WELWYN HATFIELD COUNCIL – DEVELOPMENT CONTROL
DELEGATED REPORT

APPLICATION No:	N6/2007/0887/FP
------------------------	------------------------

The application seeks permission for the erection of a rear conservatory measuring 4.8m in width and 2.75m in depth. It would stand at a height of 3.28m to the ridge of the pitched roof. The conservatory would have a brick base and white PVCu windows on the rear elevation including a set of French doors.

PROPOSED REAR & SIDE ELEVATIONS

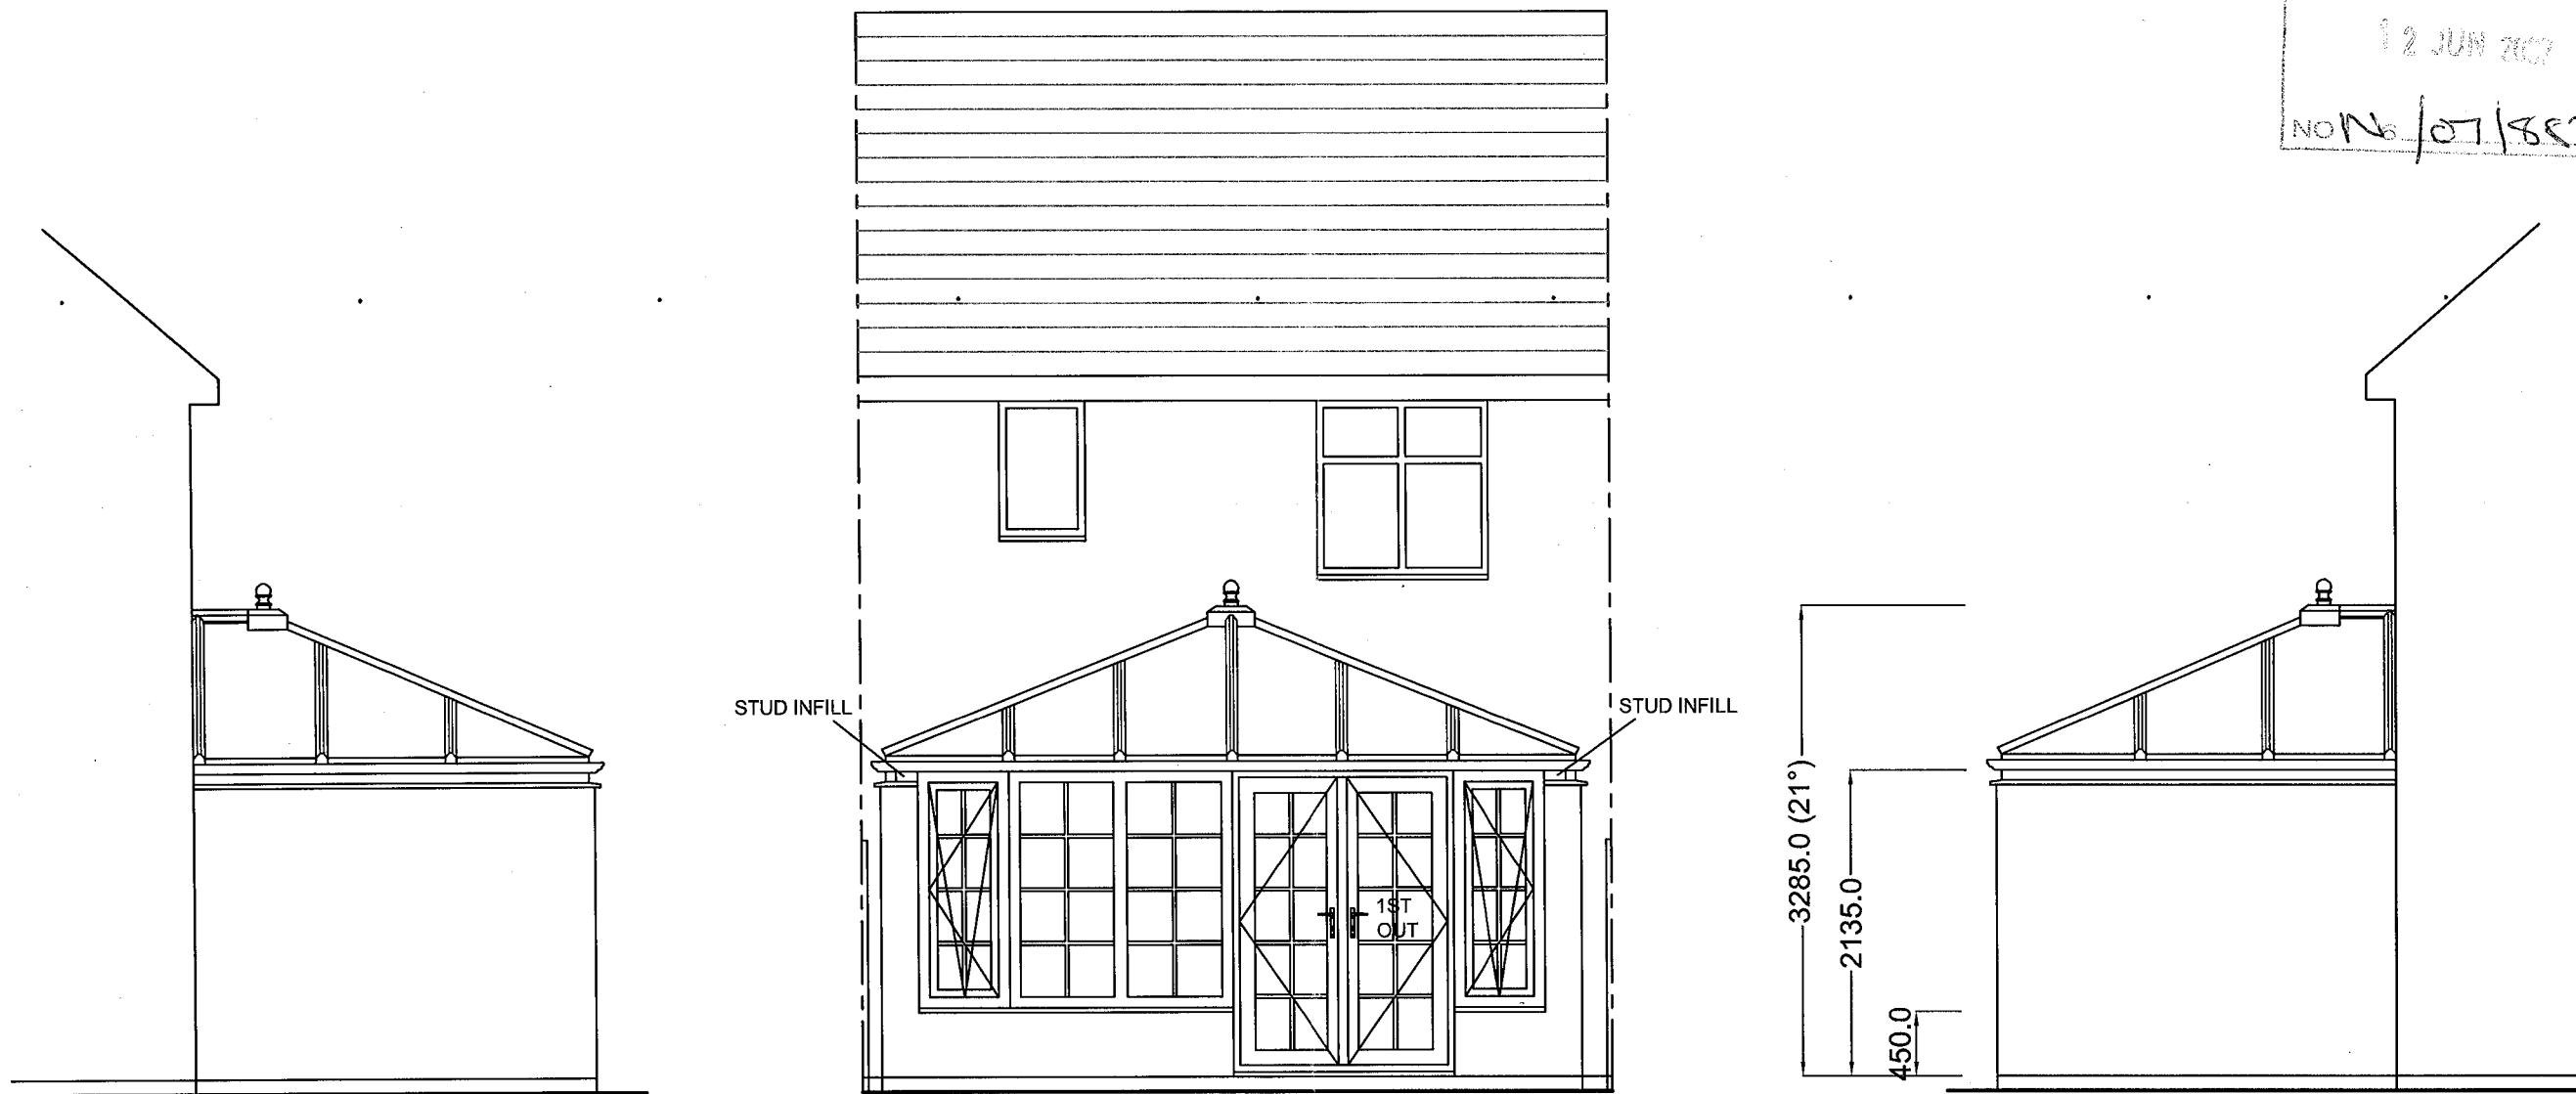
- Concern raised regarding the width of the conservatory being too large for the site;
- Issue raised regarding lack of natural ventilation in kitchen;
- Would prefer a narrower design even if projected further into garden.

The proposed development would be partially visible within the streetscene above the fence line of this and neighbouring properties. There is however a close boarded fence between properties in addition to hedgerow which maintains privacy at ground floor level.

It is acknowledged that the conservatory would span almost entirely across the rear elevation of the property, however given the design of the conservatory similar to those of the surrounding area it is not considered that it would be detrimental to the character of the site or surrounding area. In addition there would be sufficient amenity space remaining with the proposed development on site for the size of the dwelling.

2. In terms of its potential impact on the amenity of adjoining neighbours, this is considered to be limited. The extension has a simple design and any effect on neighbouring properties would be limited to that above the fence. Given the orientation of the properties, size and scale of the conservatory it is not considered that there would be any significant loss of light afforded to the properties.
3. None.
